Lead Member of the Examining Authority
North Falls Offshore Windfarm DCO
National Infrastructure Planning
Template Quay House
2 The Square, Bristol
BS1 6PN

Our Ref: 20048269
PINS Ref: EN010119
Date: 1818 March 2025
Telephone: 03330 322546

Planning Act 2008 – Application by North Falls Offshore Wind Farm Limited for an Order Granting Development Consent for the North Falls Offshore Windfarm (EN010119)

I refer to the Rule 8 letter dated 4 February 2025 which sets out the Examination Timetable for the above Development Consent Order (DCO), currently at Examination. Essex County Council (ECC) in conjunction with Tendring District Council (TDC), and as described as The Councils, would like to respond to provide a written response to the Applicant's submission at Deadline 02.

Legend

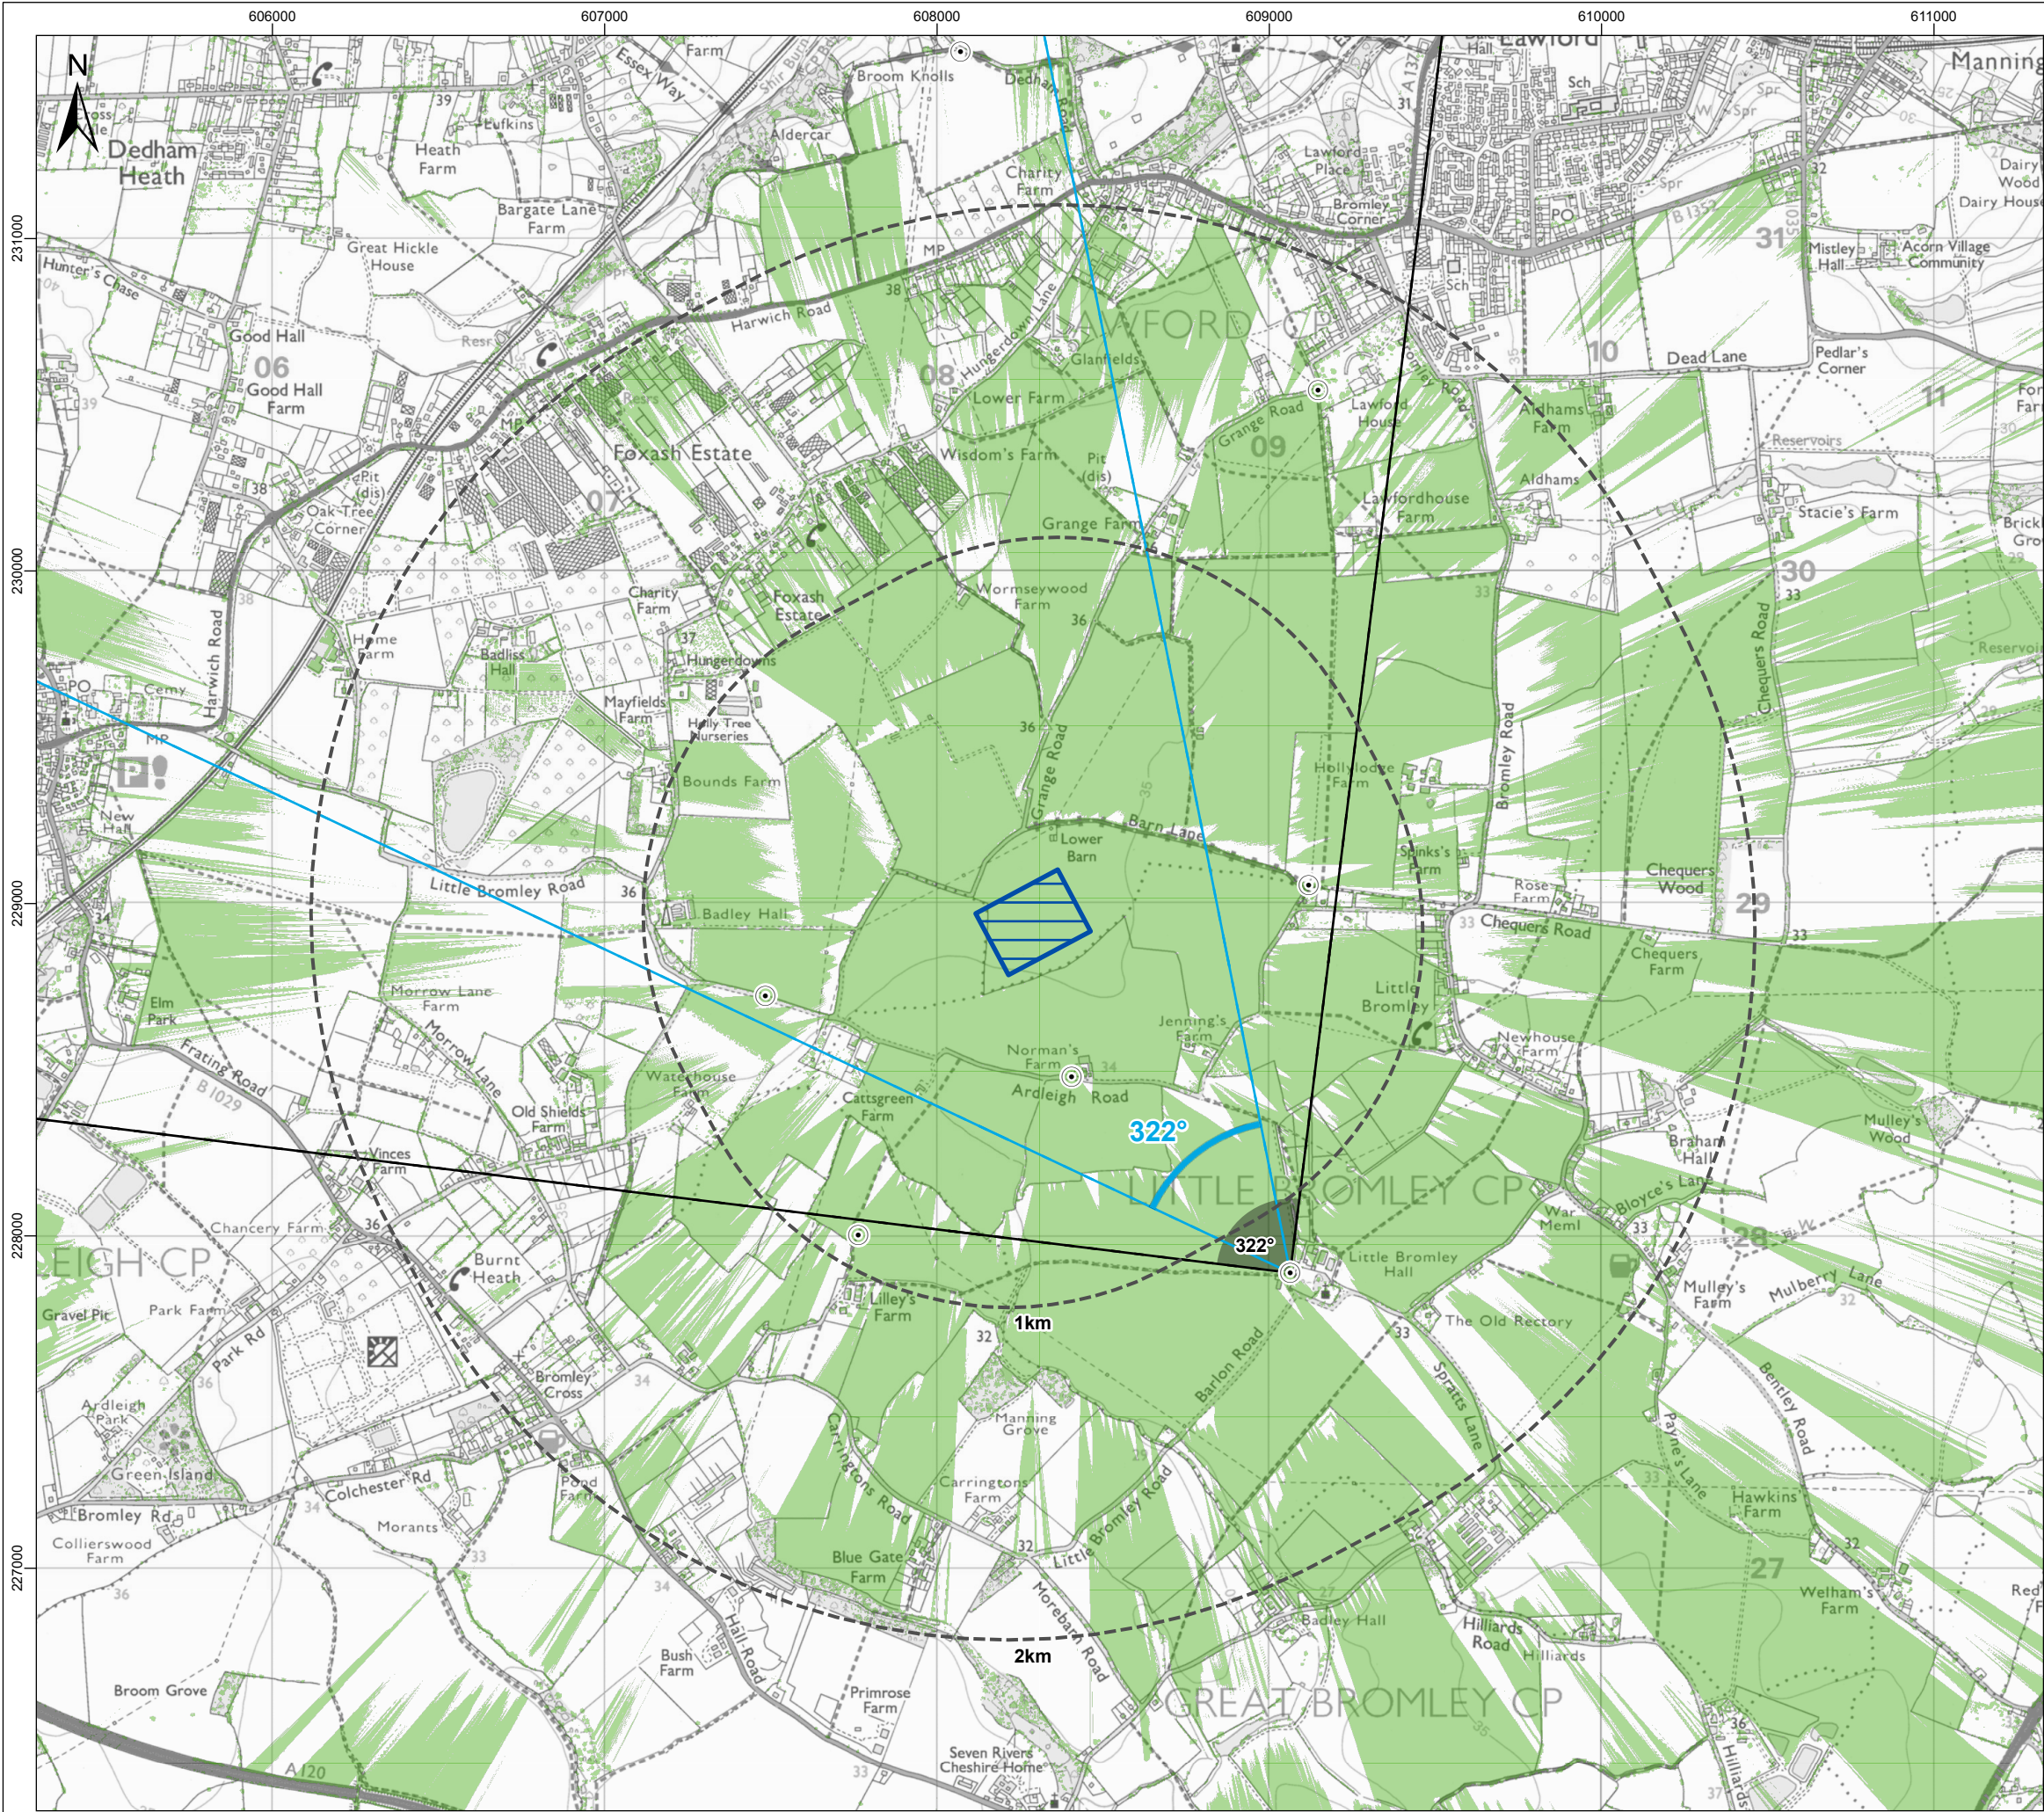
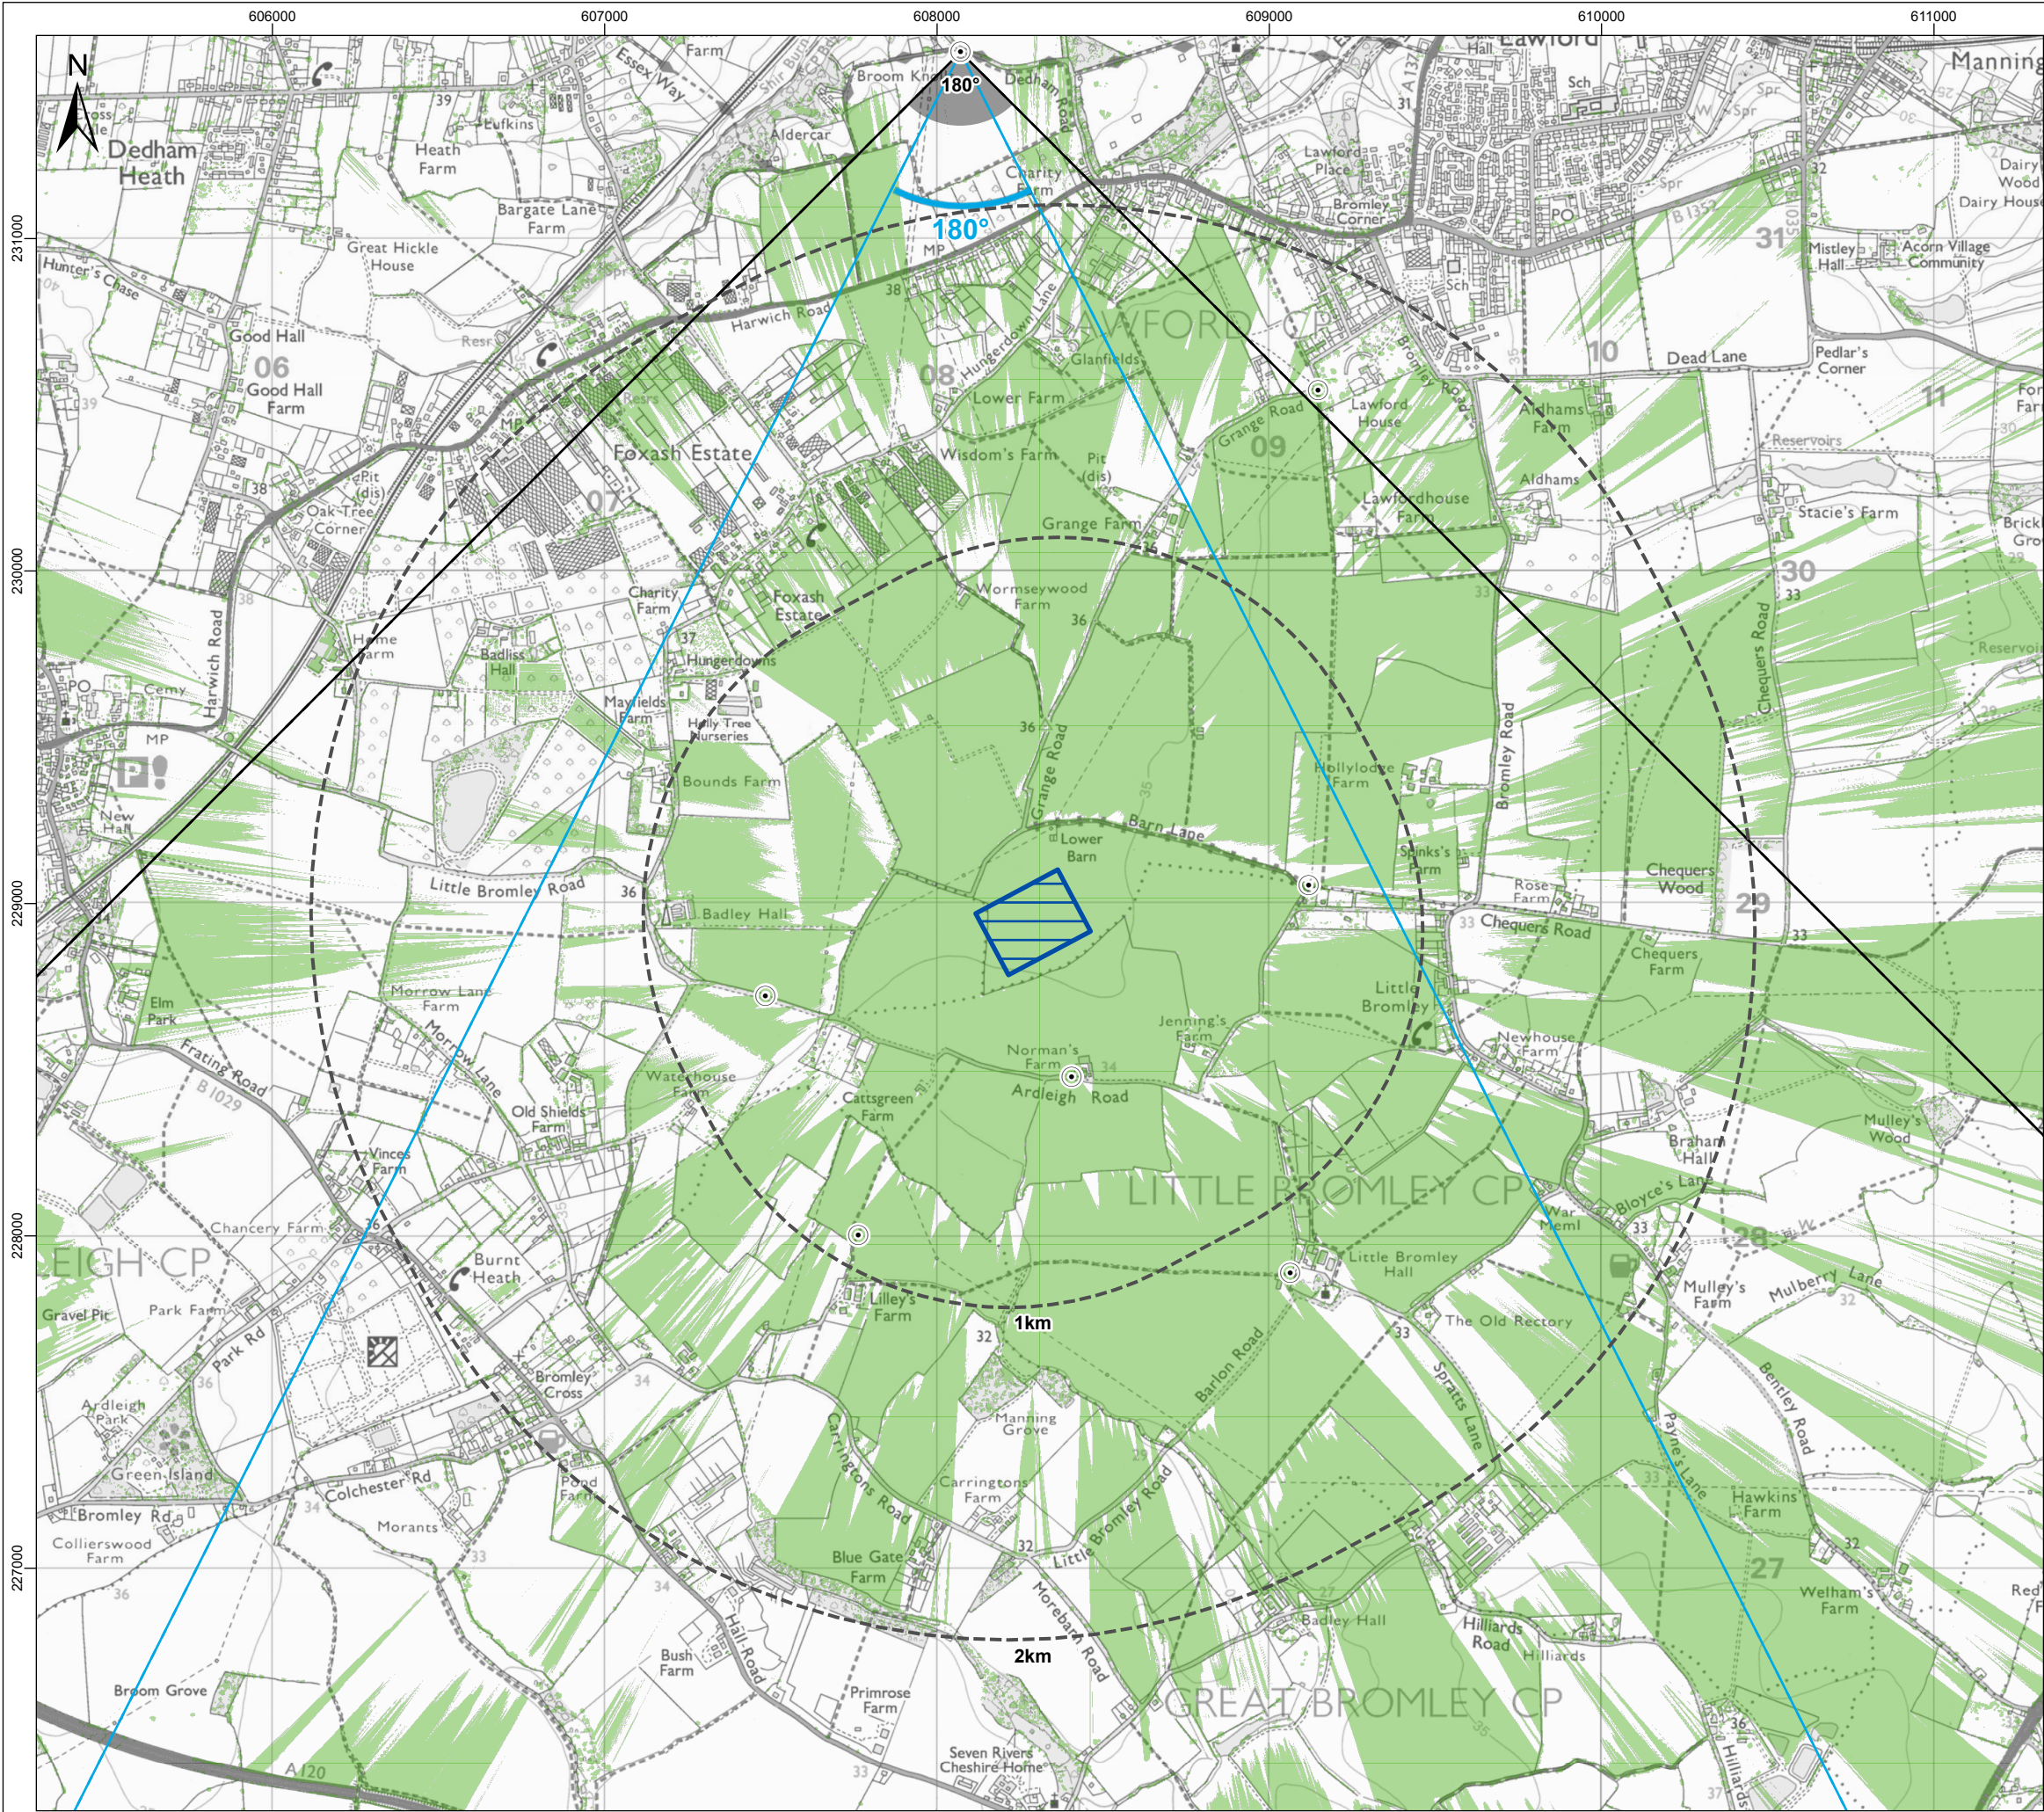
The cumulative visualisations [APP-084 to APP-088], do not demonstrably include the overhead power lines for the Norwich to Tilbury project which would connect into EACN. Therefore, we do not agree that a demonstrably meaningful cumulative assessment has taken place.
